TECHNICAL FILE NOTE 4A					 ASHLEY HELME ASSOCIATES		
Project	Henthorn Road, Clitheroe			Project No			1677
Contact		Originator	PL	Date			24.03.26

- 1.1 Ashley Helme Associates (AHA) are appointed by Gladman Developments Ltd (GDL) to provide highways/transport support for a planning application (LPA ref 3/2025/0997/OUT) for up to 115 dwellings on land off Henthorn Road, Clitheroe.
- 1.2 AHA prepared the following documents to accompany the planning application:
- (i) Transport Assessment: ref 1677/3/A, and
 - (ii) Travel Plan: ref 1677/4/A.

Drawing file: planx_downloads / 25_0997_3_Proposed_Access_Plan.pdf

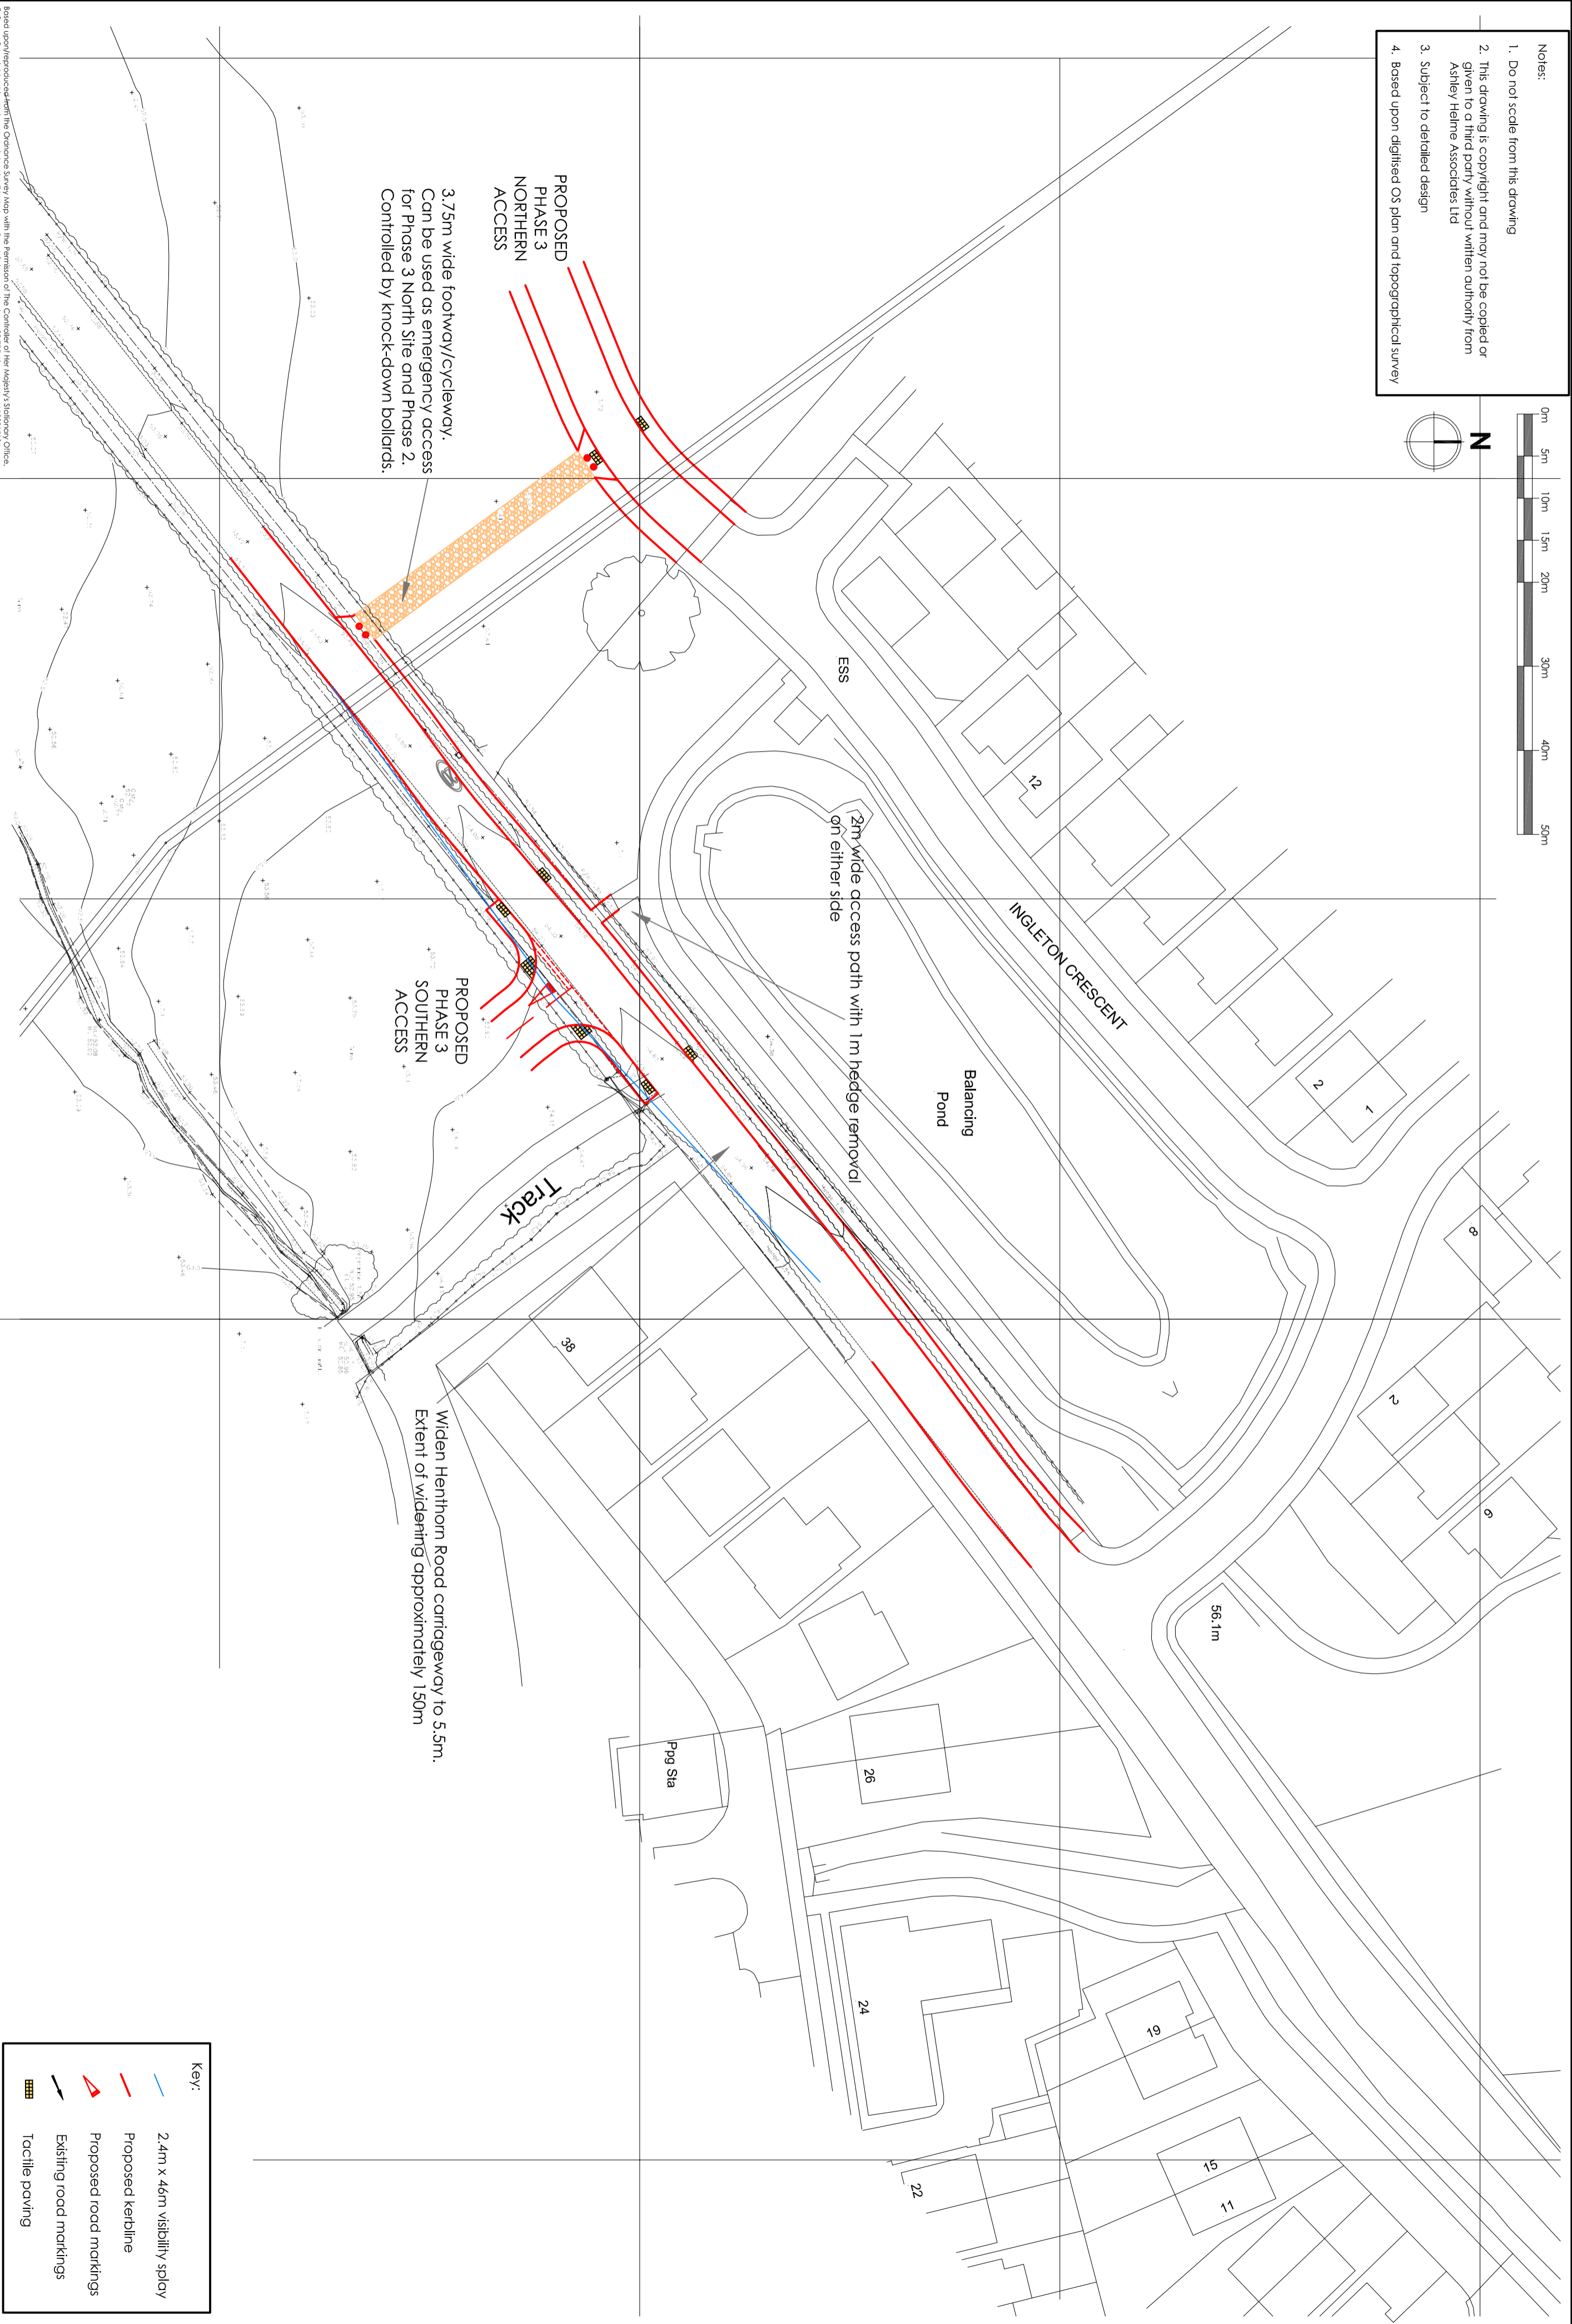
- 4.1.1 LCC confirm acceptance of the access arrangements to serve the Northern parcel on Henthorn Road. LCC confirm that the emergency access is "*necessary and acceptable*" but have requested visibility splays are shown at the emergency access. The visibility splays requested are 2.4m x 46m based on the recorded 85%ile speed data on Henthorn Road. LCC state:

"A secondary emergency access arrangement is also provided within drawing number 1677/01, revision F, to provide access to the development which sits to the north of Henthorn Road, as well as serving as an emergency access to the Phase 2 development. The emergency access is 3.75m wide and controlled by knock-down bollards positioned on both sides. The access will require a visibility splay of 2.4m by 46m (based upon recorded speeds) in both directions; this will be achievable within the site boundary and over the newly adopted footway provisions.

4.1.3 LCC raise the requirement for a footway on Henthorn Road to extend on the north side of the road to an existing private road where the Ribble Way Public Right of Way is aligned. LCC state:

"On the north side of Henthorn Road, a new footway is proposed that will connect into the existing footway at the junction with Waterfall Gardens. A new footway is proposed for approximately 140m in the other direction until it meets the proposed secondary emergency access arrangement, where it terminates.

However, given the 85th percentile speeds, (32.4 mph Northbound and 32.5mph Southbound) recorded for the visibility splays, at which vehicles travel along Henthorn Road there are pedestrian safety concerns due to the lack of footway provision beyond what is currently proposed. Shared space arrangements are only recommended where vehicle speeds and flows are very low. Given the intensification of vehicle and pedestrian movements, the LHA require 2m footway provisions to be provided along the North side of the entire site frontage up to the private access road, named Ribble Way, within the development framework plan provided. This private access road also features Public Right of Way, FP0301017. The footway shall also feature street lighting provisions along its full length to adoptable standards to be agreed upon as part of the Section 278 works with Lancashire County Council."

4.2.1 In reference to the proposed access on the south side of Henthorn Road, LCC raise the following with respect to visibility splays:

"The applicant has provided visibility splays at the southern site access with Henthorn Road of 2.4m by 46m in both directions. It is understood that the applicant has offset the visibility splay to the right by 1m, however the LHA is of the opinion that the verge forms part of the adopted highway and, as such, the visibility splay should remain within the highway or the applicant's site without being offset. We ask that this be amended."

4.3.1 LCC raise comments relating to existing, recorded speeds on Henthorn Road and the requirement for a traffic calming scheme, to comprise road markings and signage. LCC state:

"The data demonstrates that there is a lack of self-compliance of the speed limit on Henthorn Road and subsequently we would request that mitigation measures are provided to address

these concerns. It is understood that the applicant has also included some additional 20mph road marking as part of the site access layout. These measures are welcomed and in addition, a more robust traffic calming scheme is requested, including signing and road markings, which will be required as part of the site's mitigation measures. These shall be undertaken as part of the Section 278 works and subject to technical detail design."

4.1.2 Drg No 1677/01/G has been prepared which shows the provision of 2.4m x 46m visibility splays at the emergency access. This addresses the comment raised by LCC.

4.1.4 Drg No 1677/01/G has been prepared which shows the provision a footway on the north side of Henthorn Road as requested by LCC. The proposed footway measures 2.0m wide and street lighting is to be extended along the length of the footway from its existing termination point to the east. The precise lighting details will be agreed at detailed design.

4.2.2 Drg No 1677/01/G has been prepared which shows the provision of 2.4m x 46m visibility splay measured to the nearside kerb in both directions. This addresses the comment raised by LCC.

- 4.3.2 Drg No 1677/01/G has been prepared which shows the provision of 'Slow' markings and 20mph roundels on the carriageway on Henthorn Road. It is proposed that the road markings are complimented by repeater signs along the Site frontage to reinforce the 20mph speed limit on Henthorn Road. The precise details of the traffic calming scheme can be agreed at the detailed design stage but these measures are indicated on the proposed Site access drawing (ref 1677/01/G). This addresses the comments raised by LCC.
